An
Coimisiún
Pleanála

Commission Order
ABP-320327-24

Planning Authority: Wicklow County Council

Planning Register Reference Number: EX53/2024

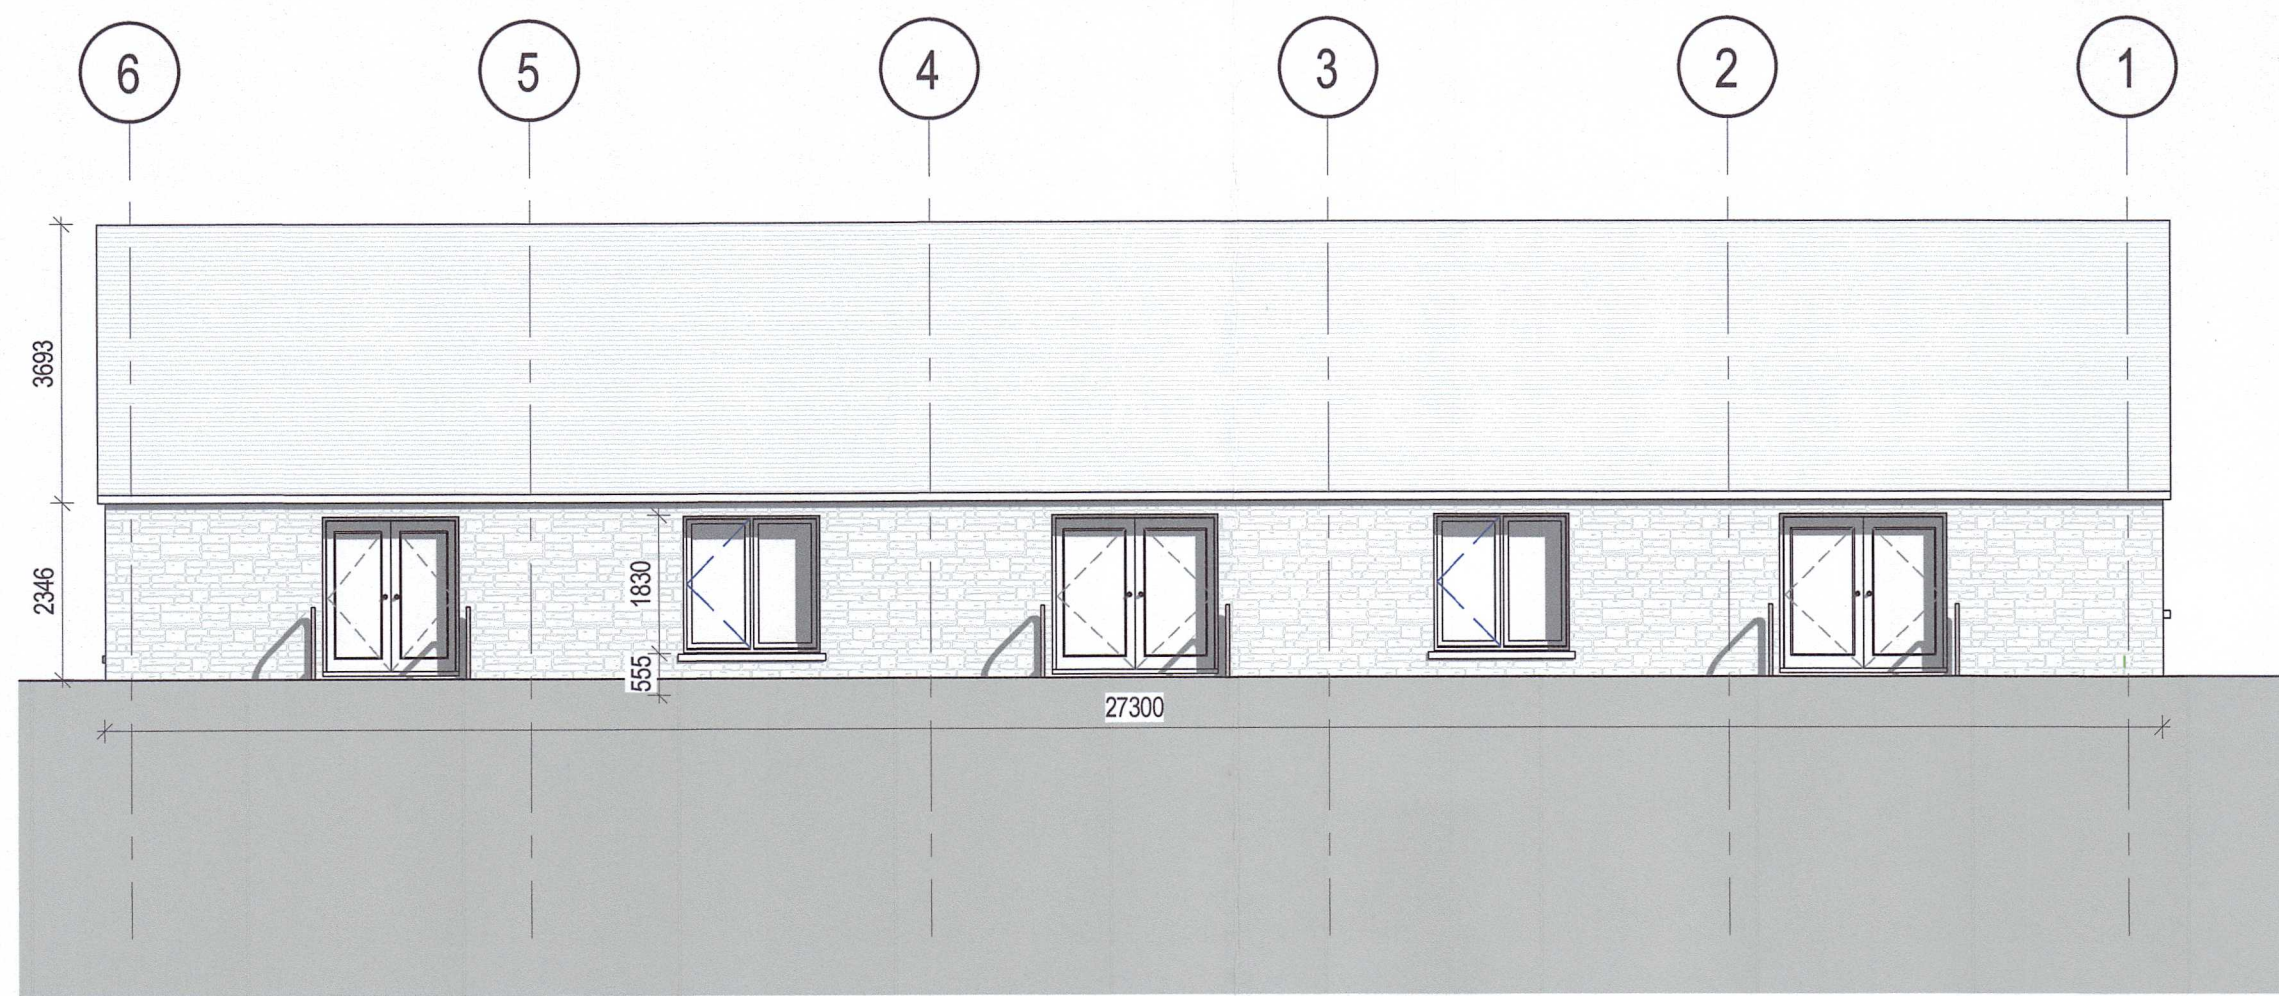
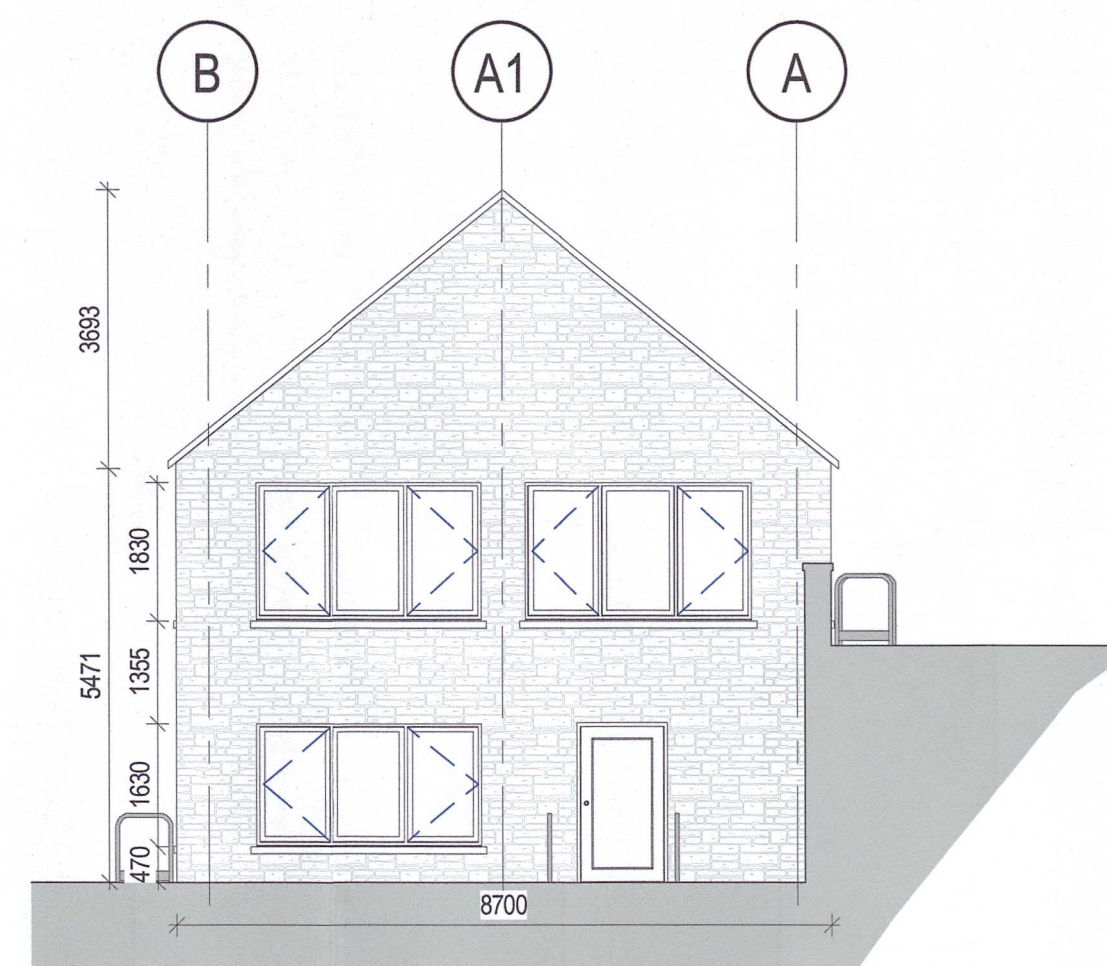
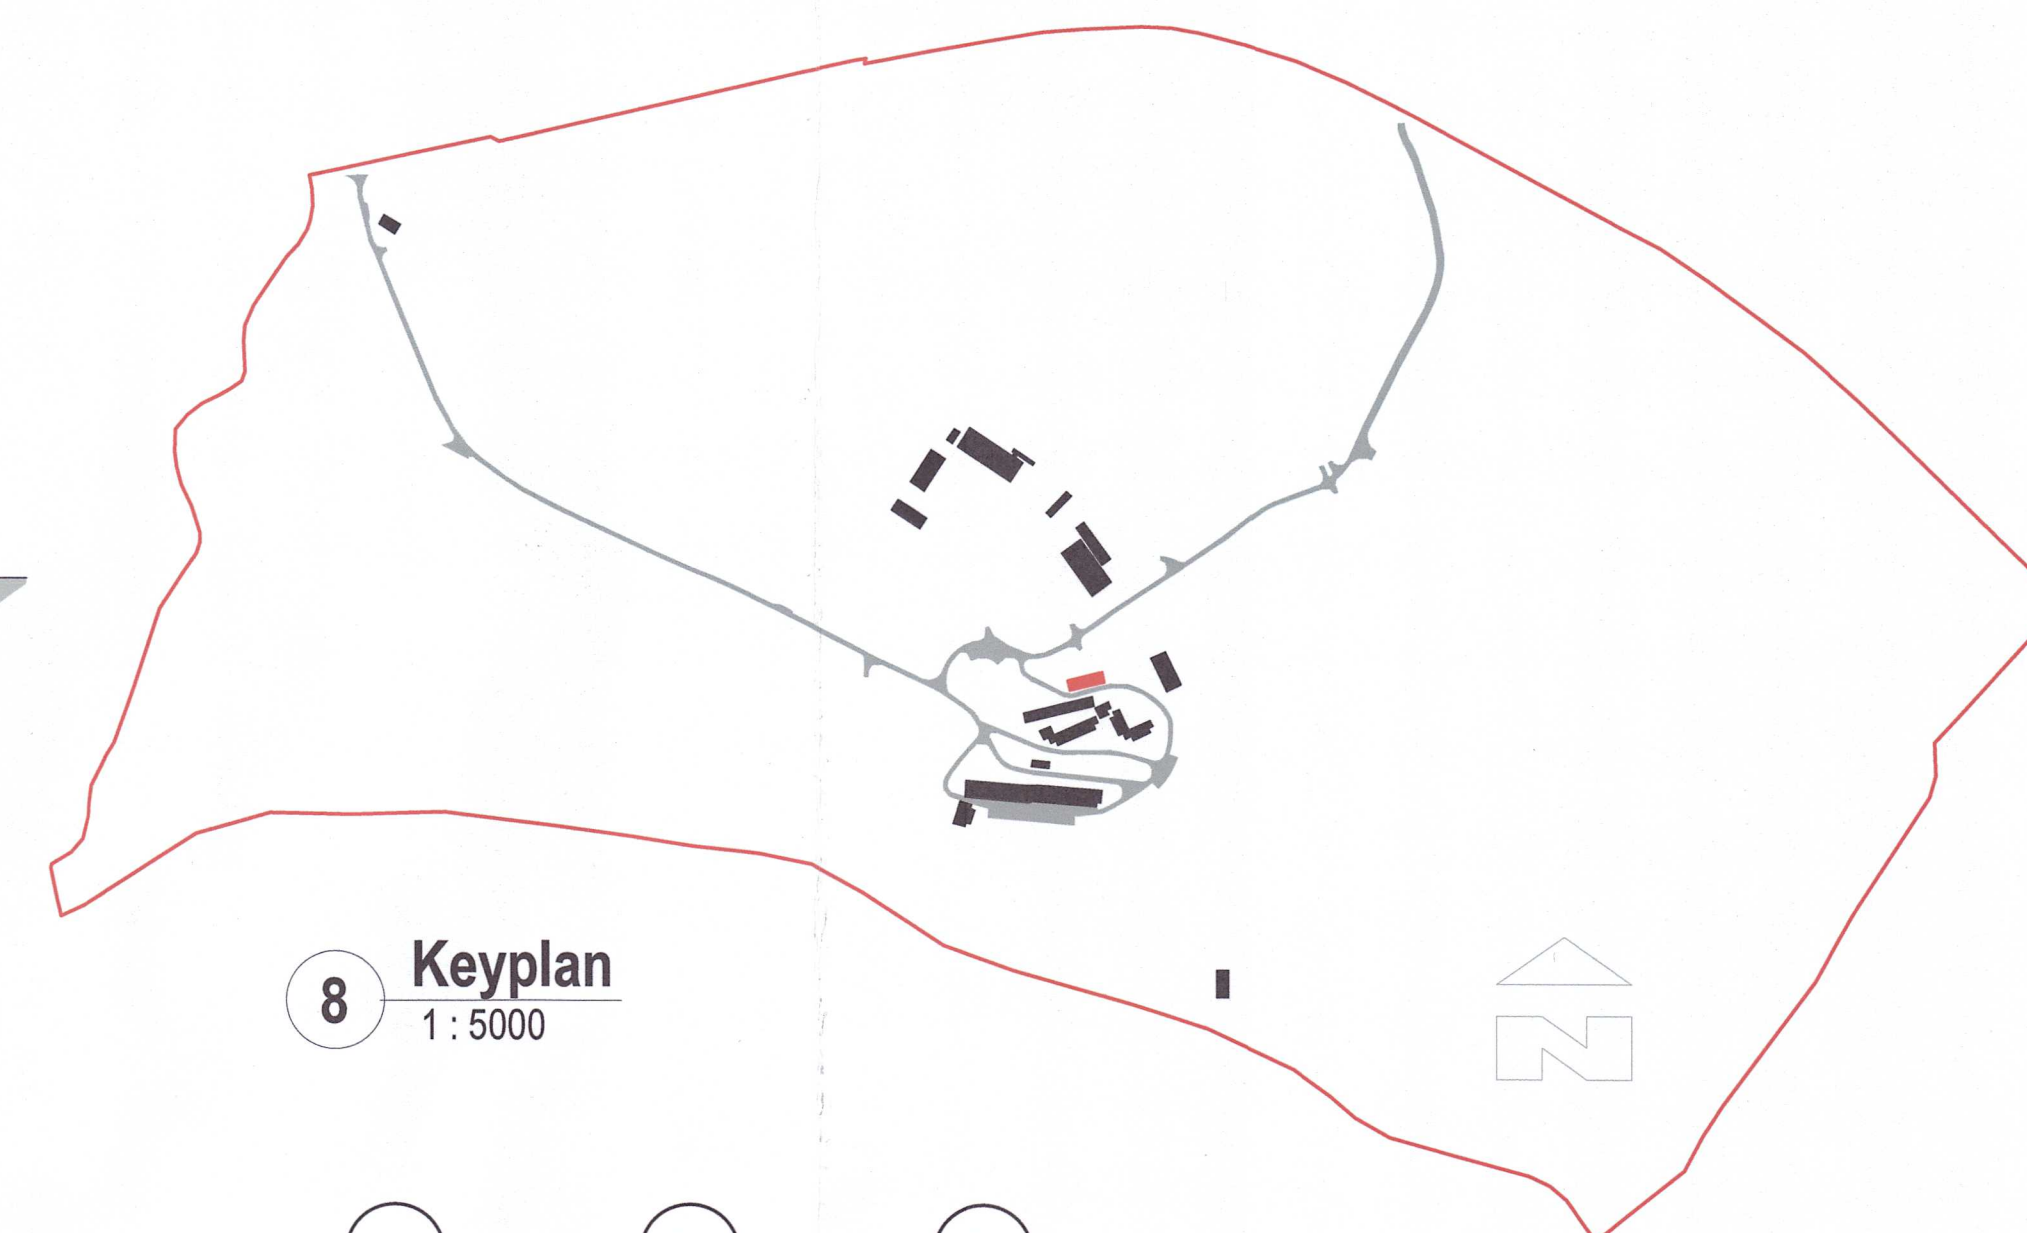
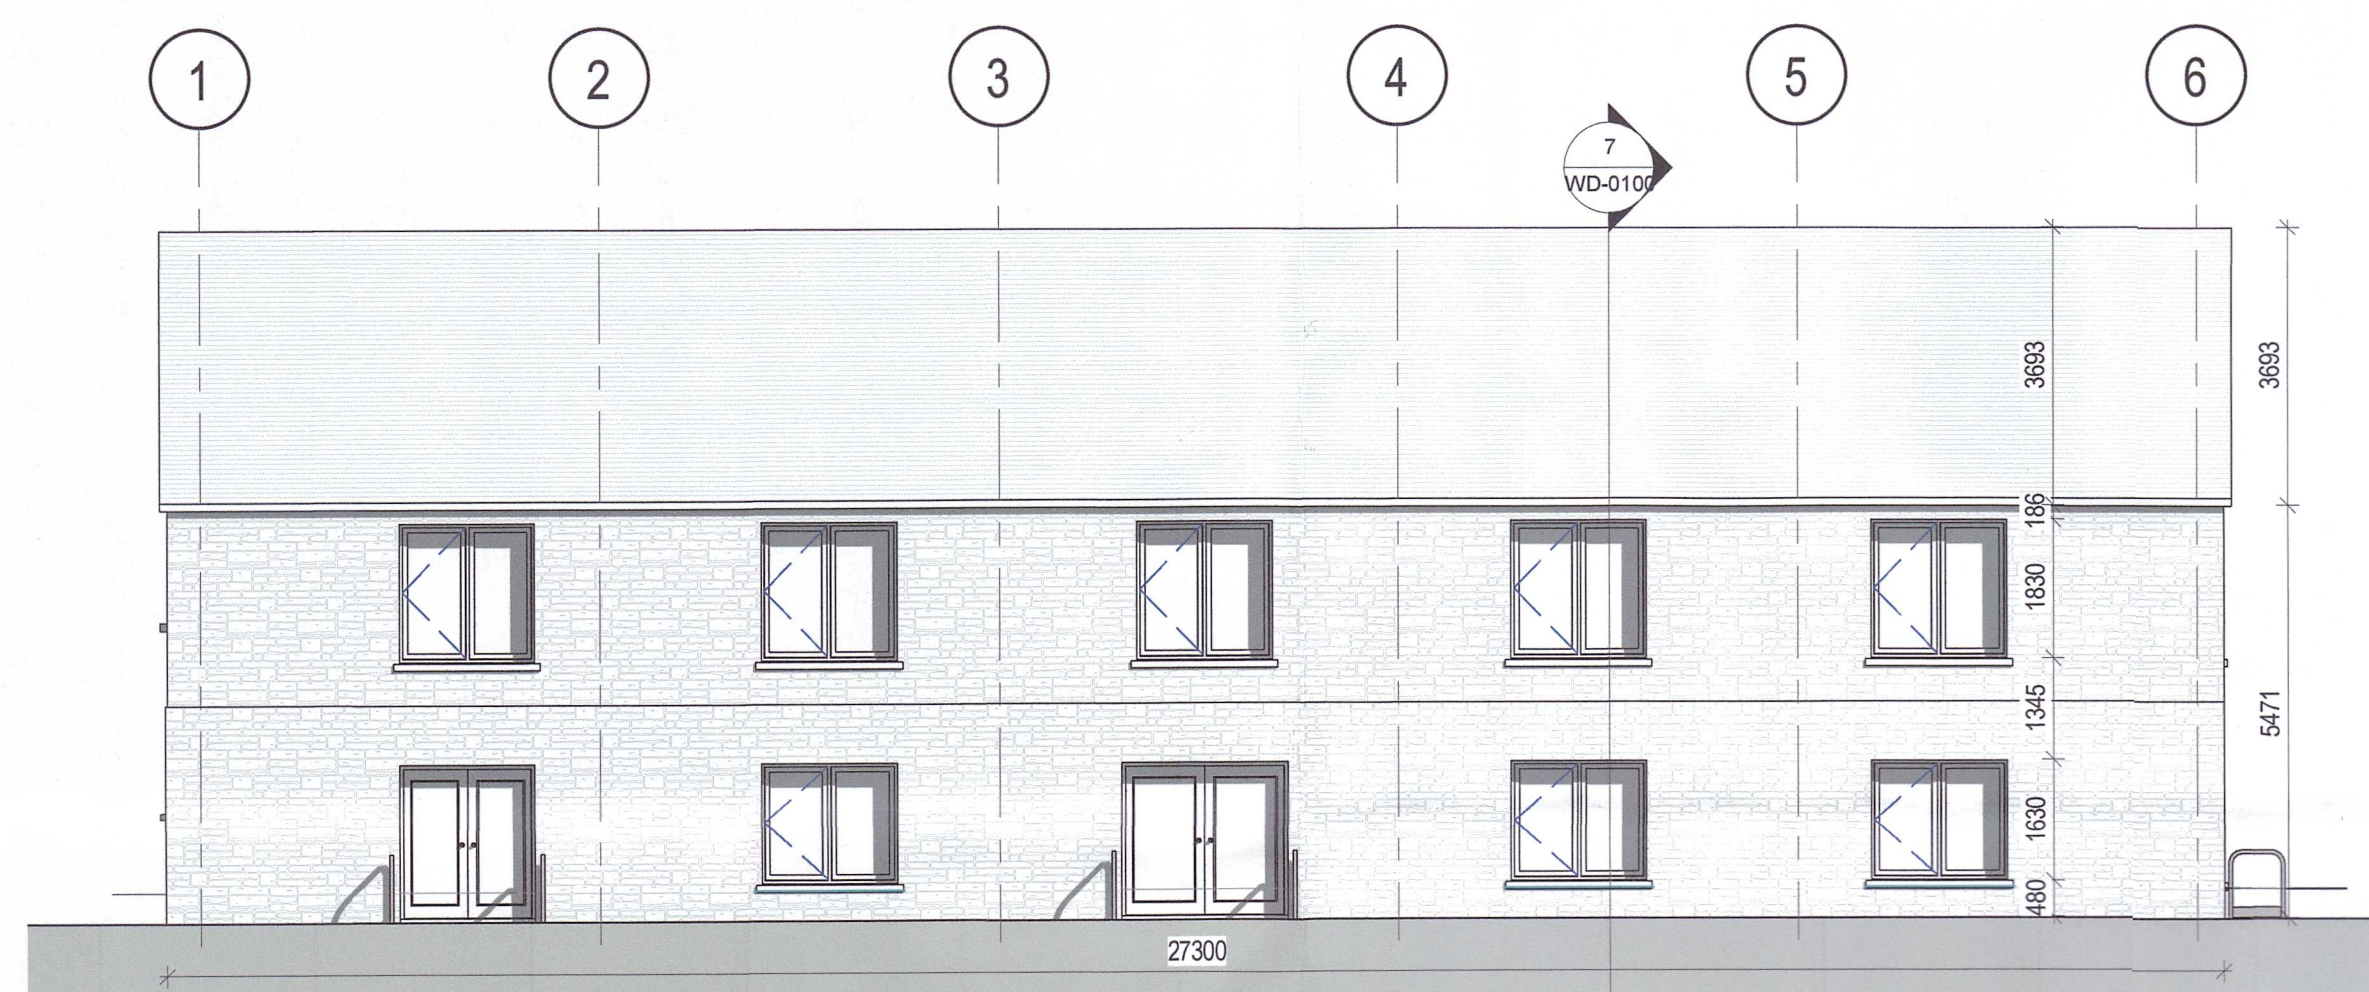
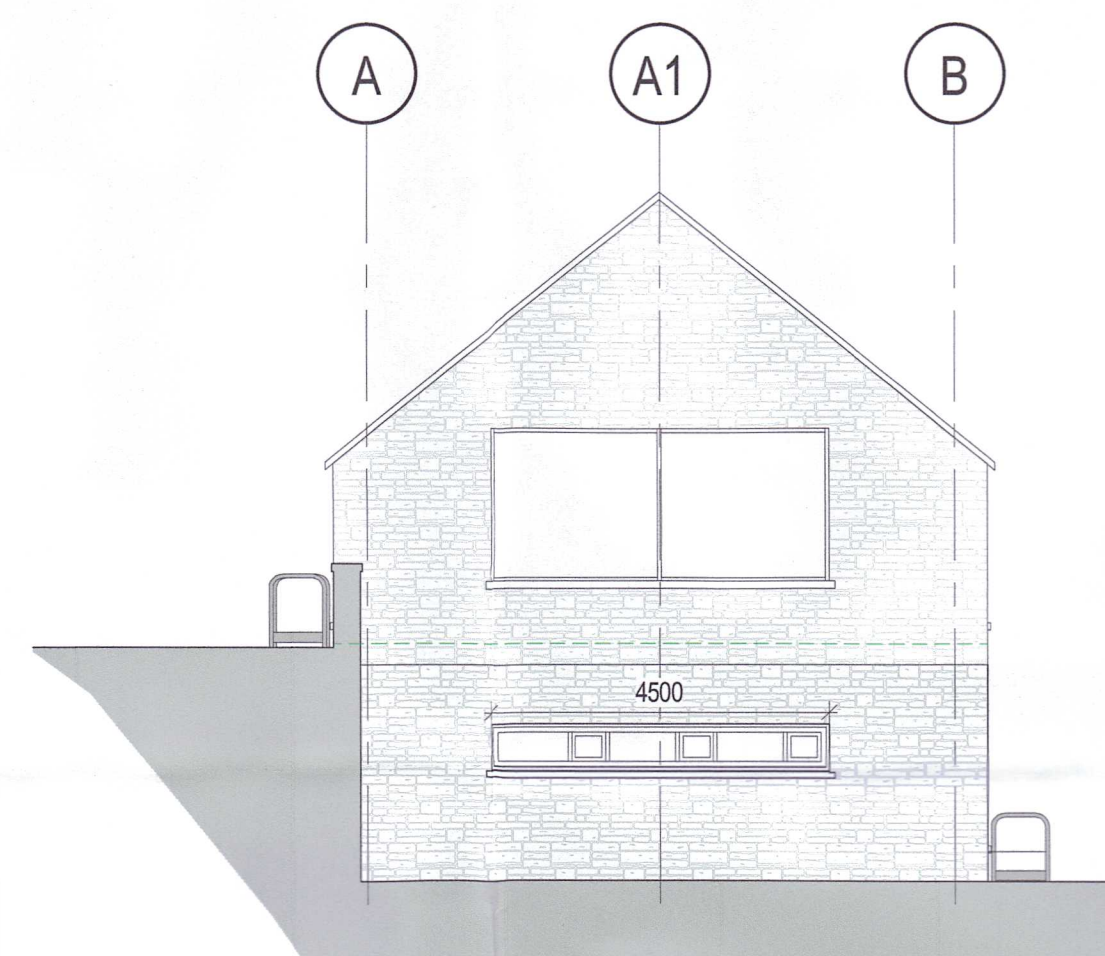
- (g) Structure Number 7 and Structure Number 8: The construction of the pavilion and kitchen buildings do not come within the scope of Section 4(1)(h) of the Planning and Development Act 2000, as amended, as they are new structures. Therefore, these structures do not constitute exempted development.
- (h) Structure Number 10: Having regard to the significant nature and scale of the works to the original structure 'Belfry' and the development approved under planning authority Register Reference 05/2792 the works do come within the scope of Section 4(1)(h) of the Planning and Development Act, 2000, as the works materially affects the external appearance of the structure so as to render its appearance inconsistent with the character of the structure. Therefore, the works do not constitute exempted development.
